Application for approval of details reserved by condition.
Town and Country Planning Act 1990
Planning (Listed Buildings and Conservation Areas) Act 1990

9 No. dwellings with associated car parking, bin storage & landscaping & creation of new access road from existing access onto West Walberton Lane. This application is a Departure from the Development Plan.

Planning Ref: WA/75/17/PL

Amended layout plan showing a change of orientation of pond and details of amended headwalls and wingwalls.

Drawing Status	AS BUILT
Client	Driftstone Developments Ltd
Project	Sunny Corner, Walberton West Sussex BN18 0QS
Drawing Title	Culvert Detail
Scale	As Shown
Date	Jul. '21
Drawn By	DJL
Checked By	MJA
Drawing No.	D1833-008
Rev.	F

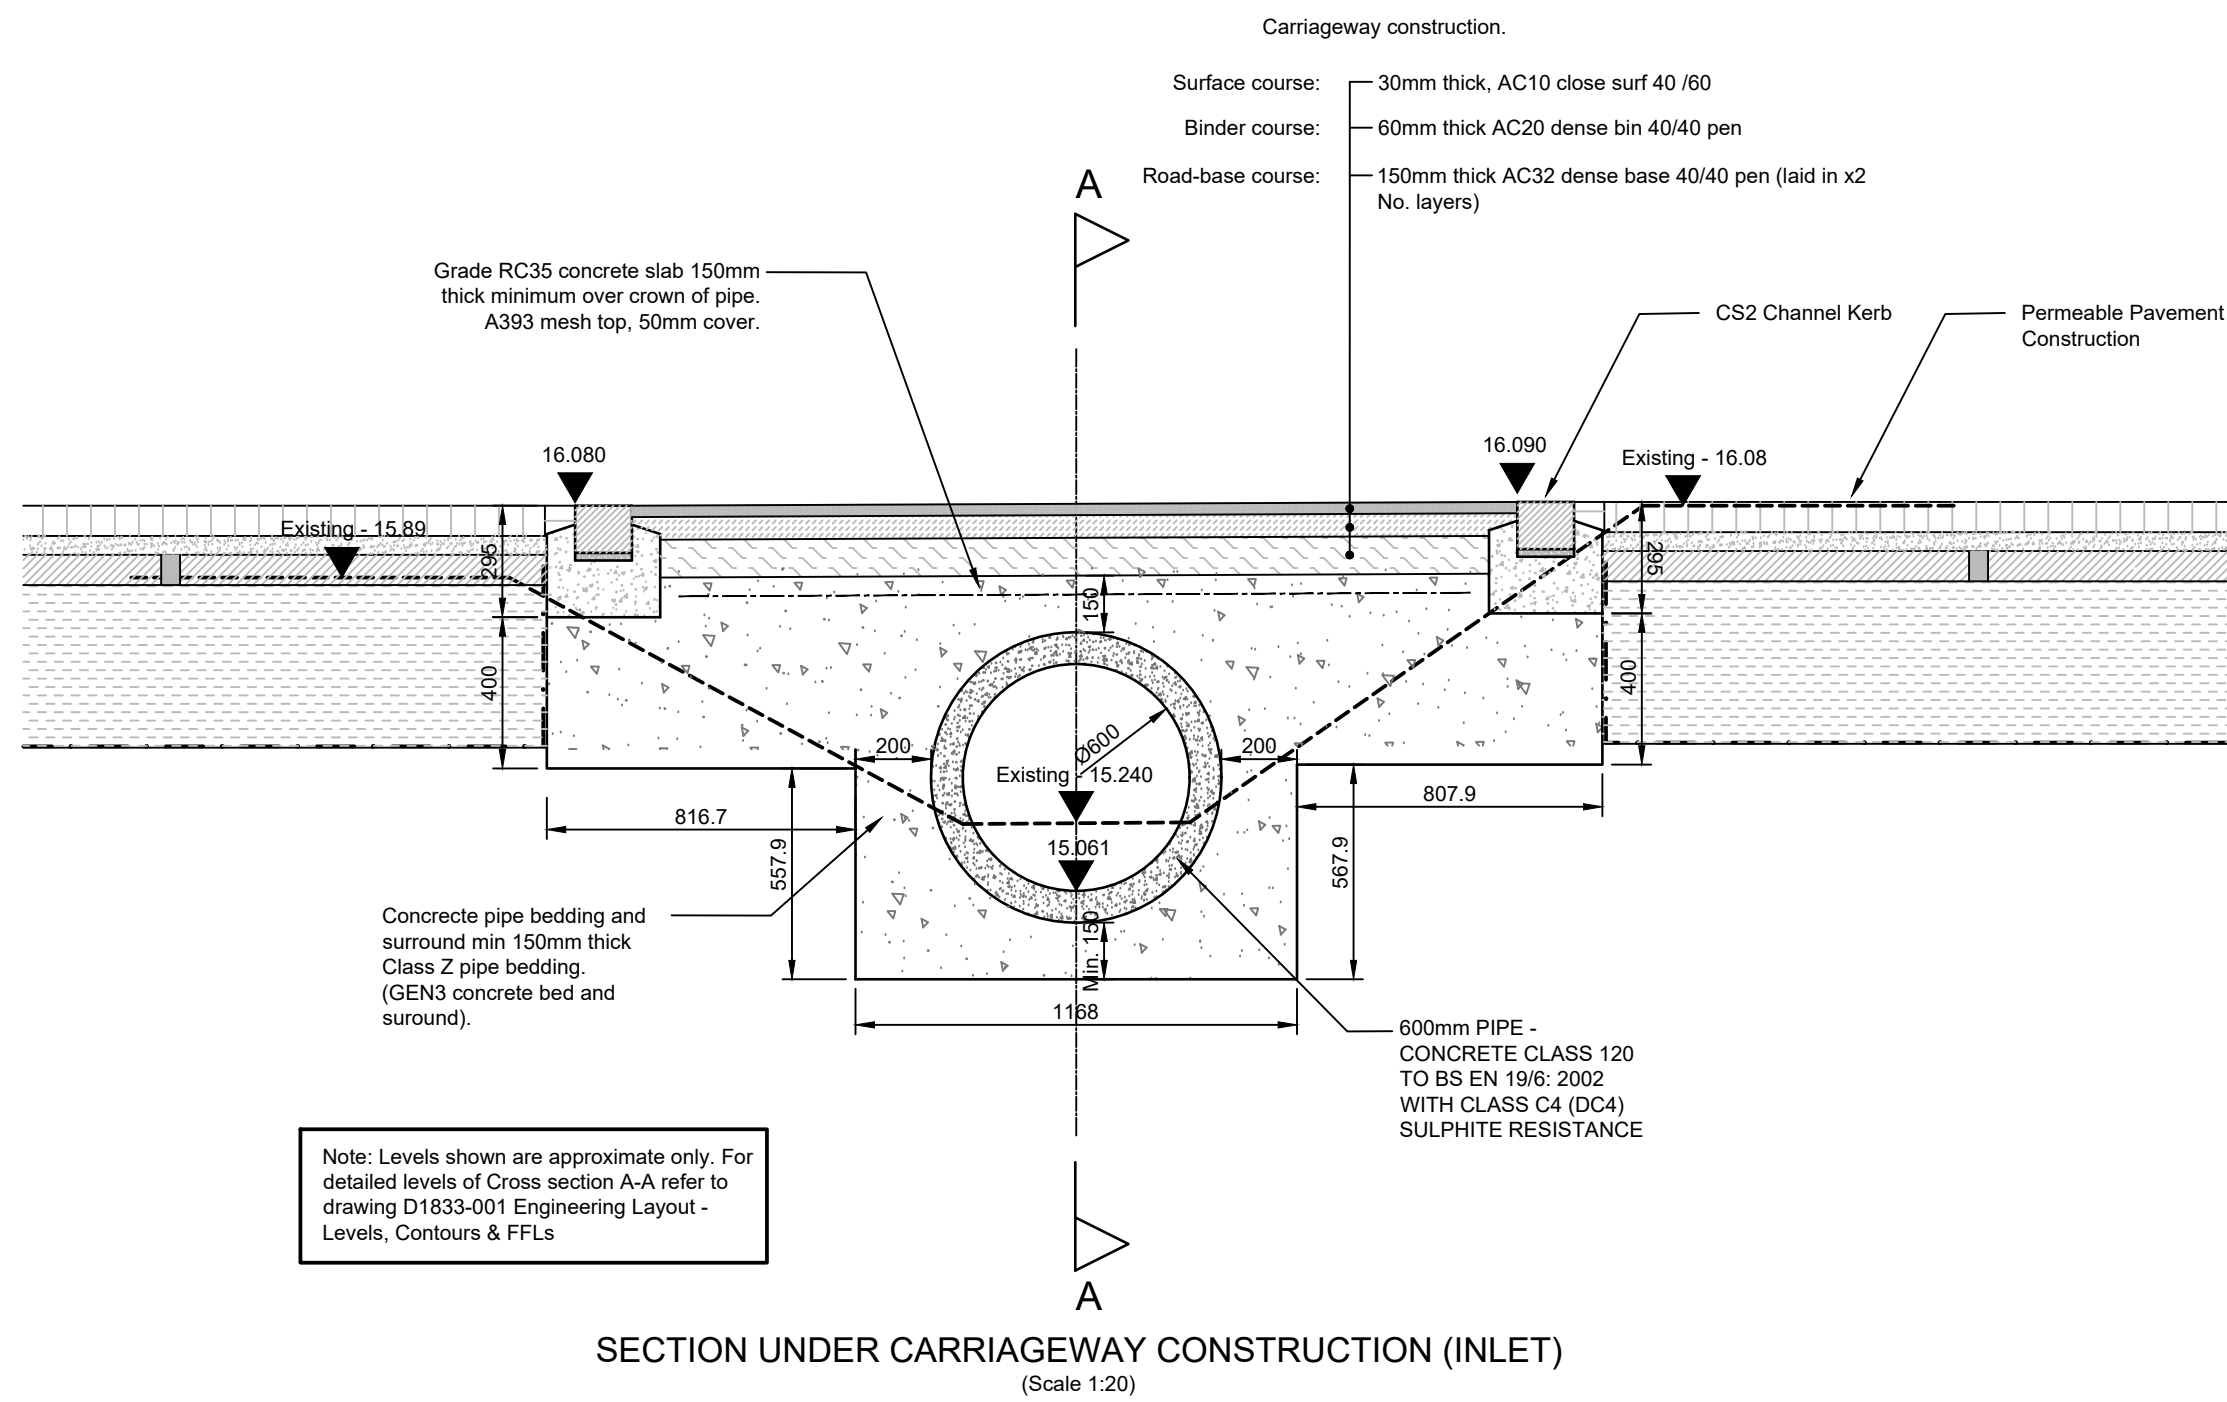
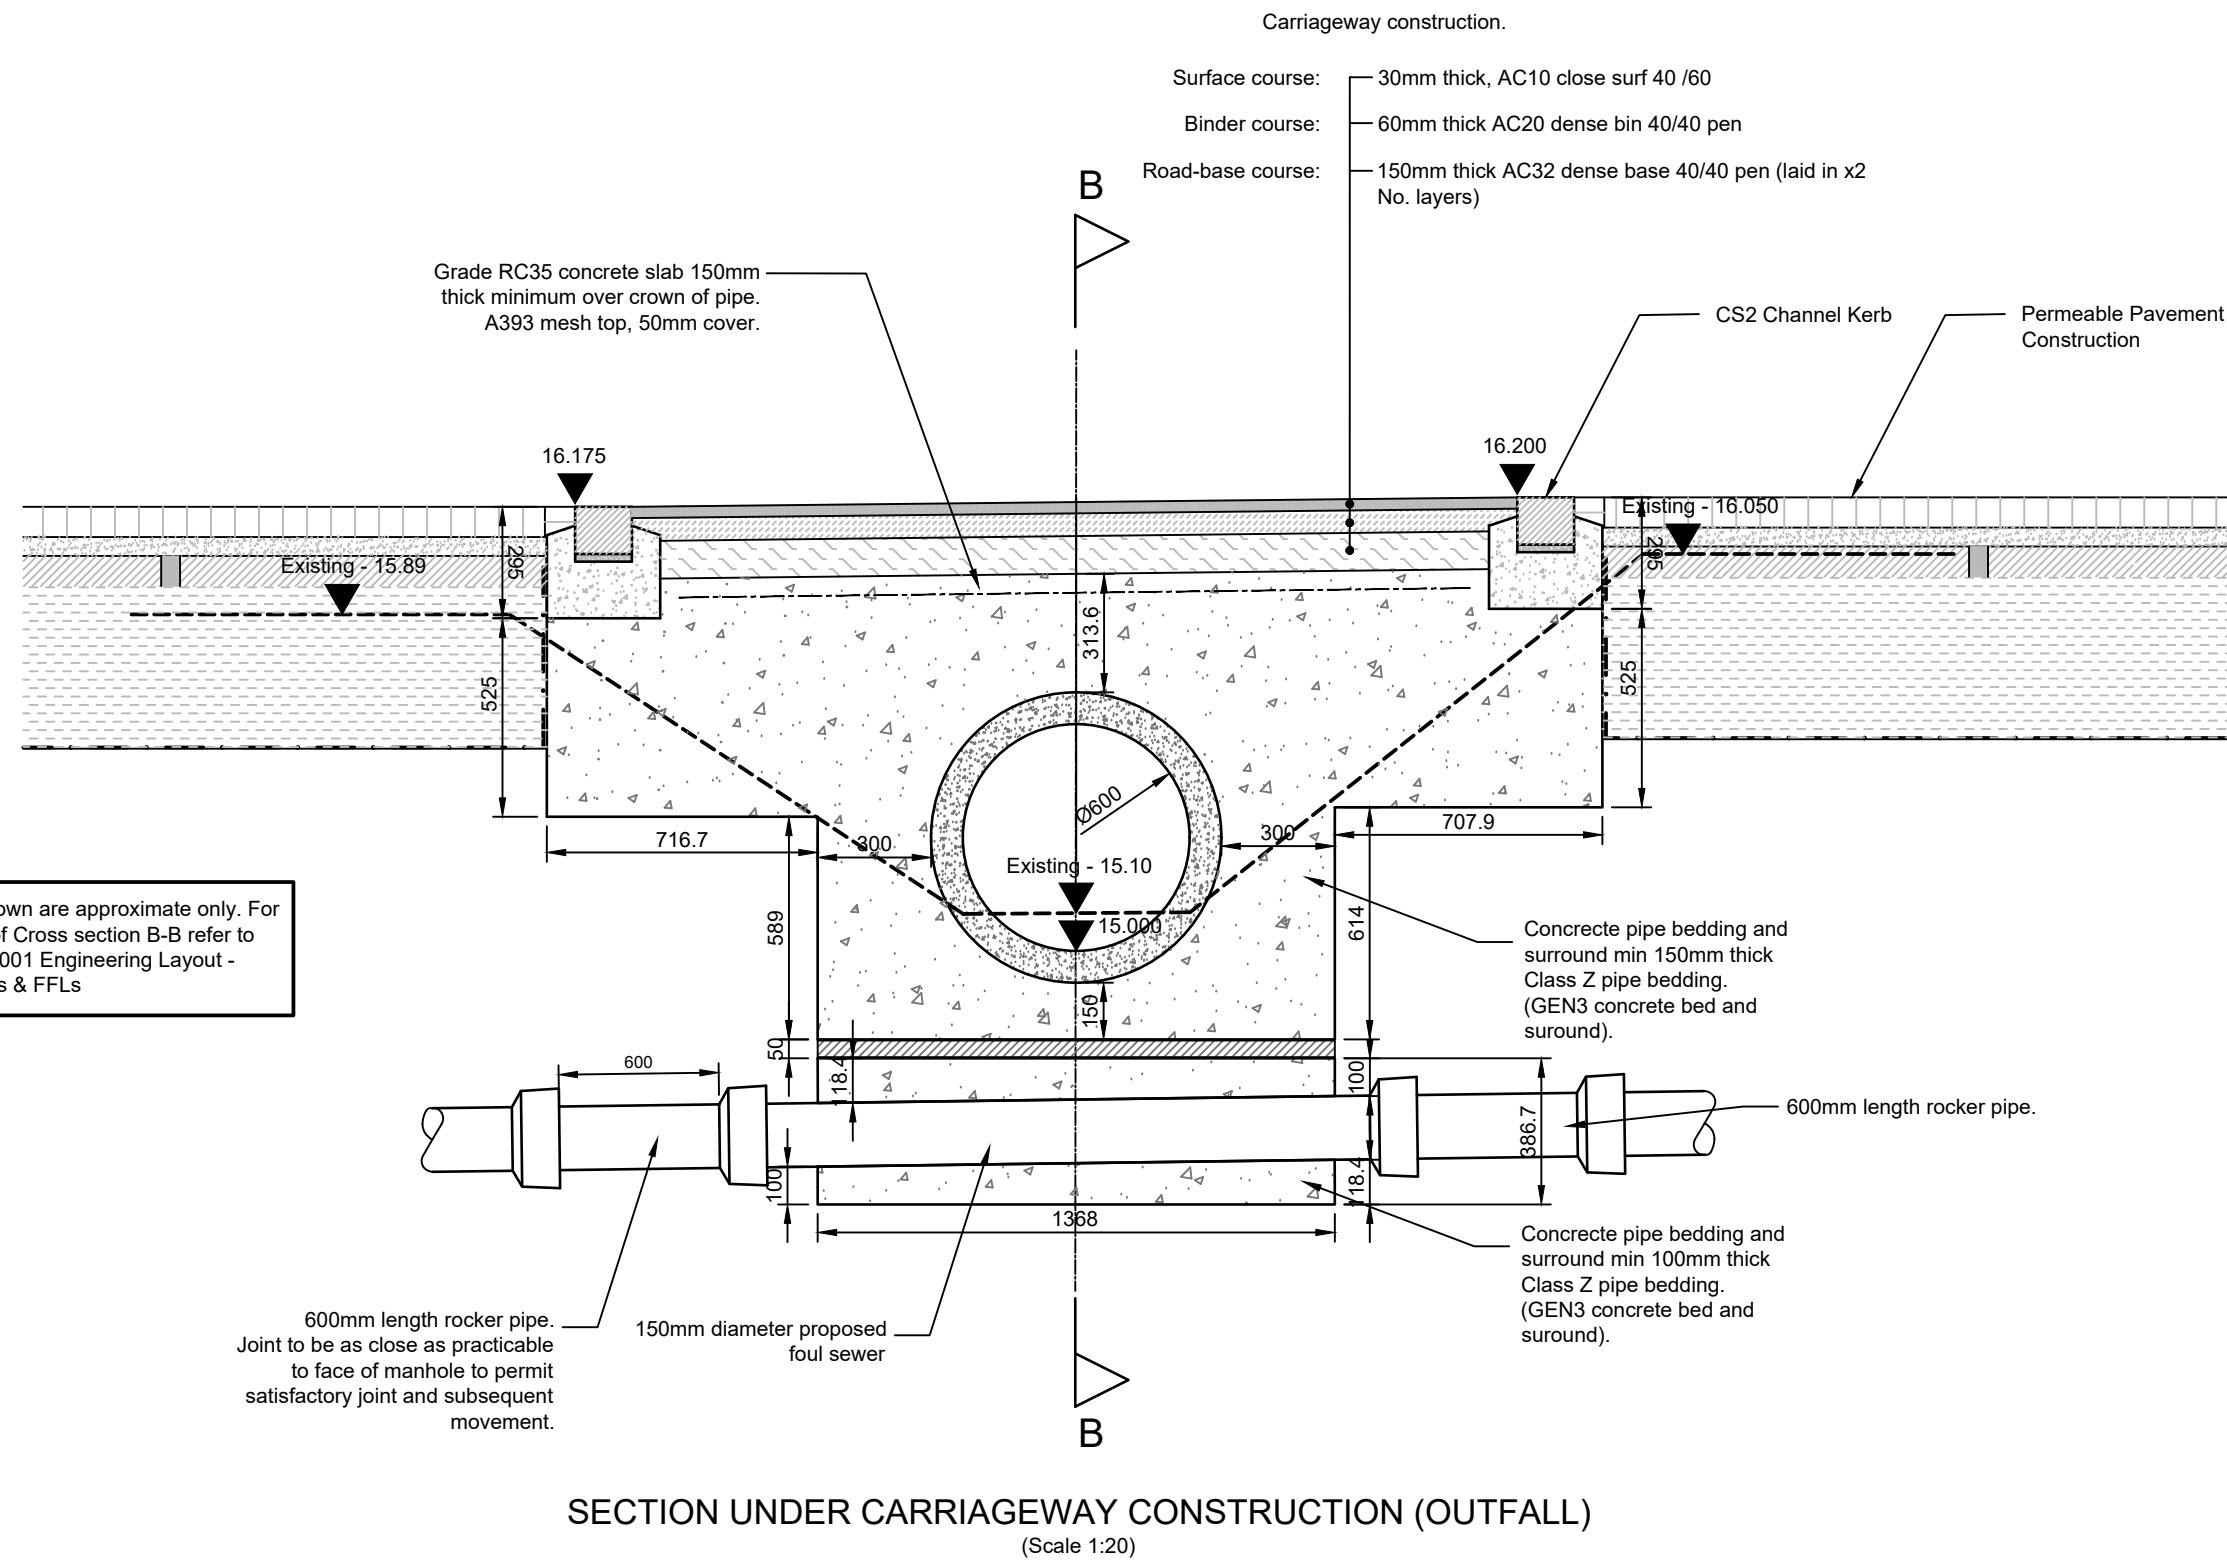
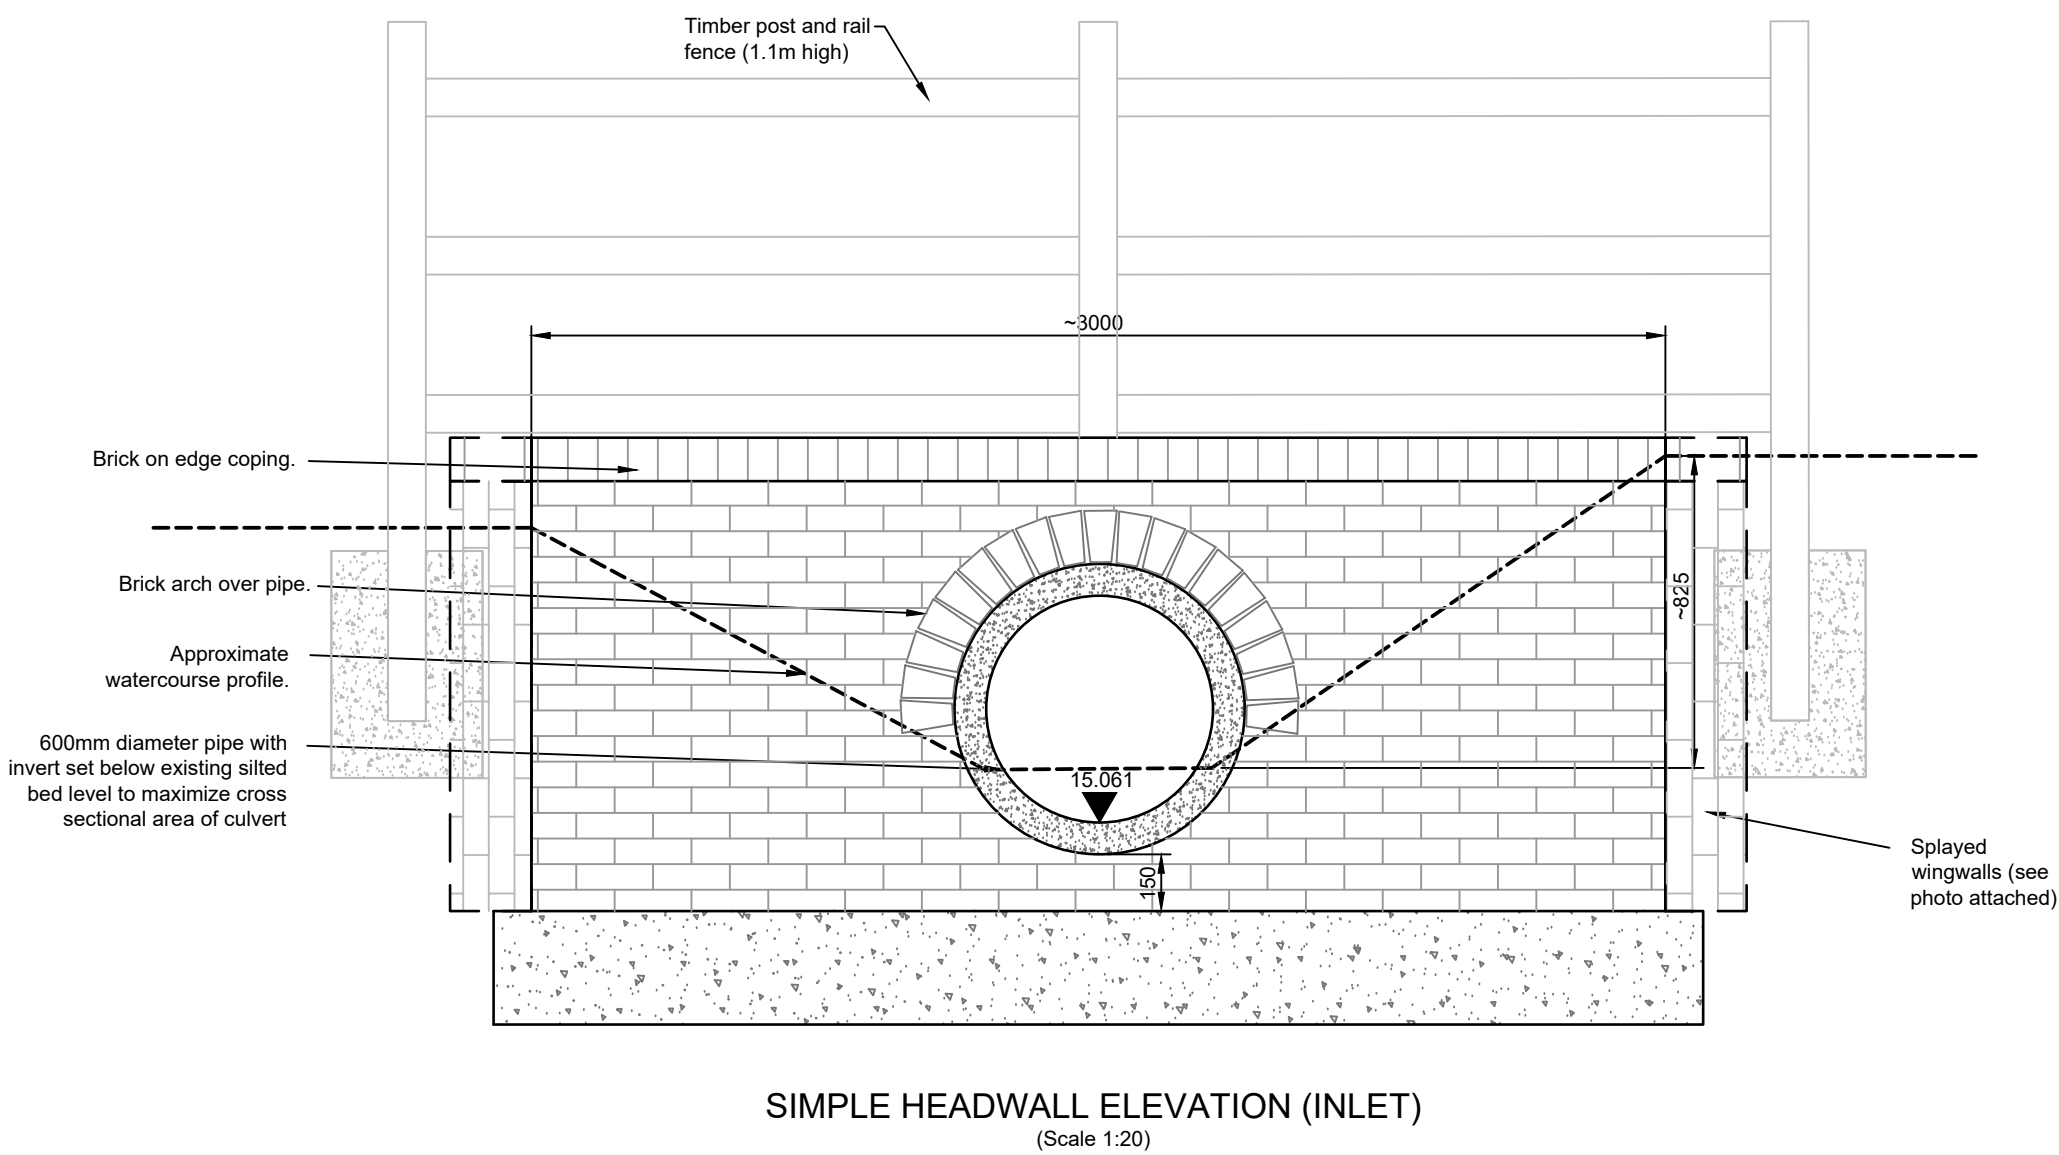
Does the upstream headwall on the culvert also now have splayed wing walls? Please include on drawing if so.
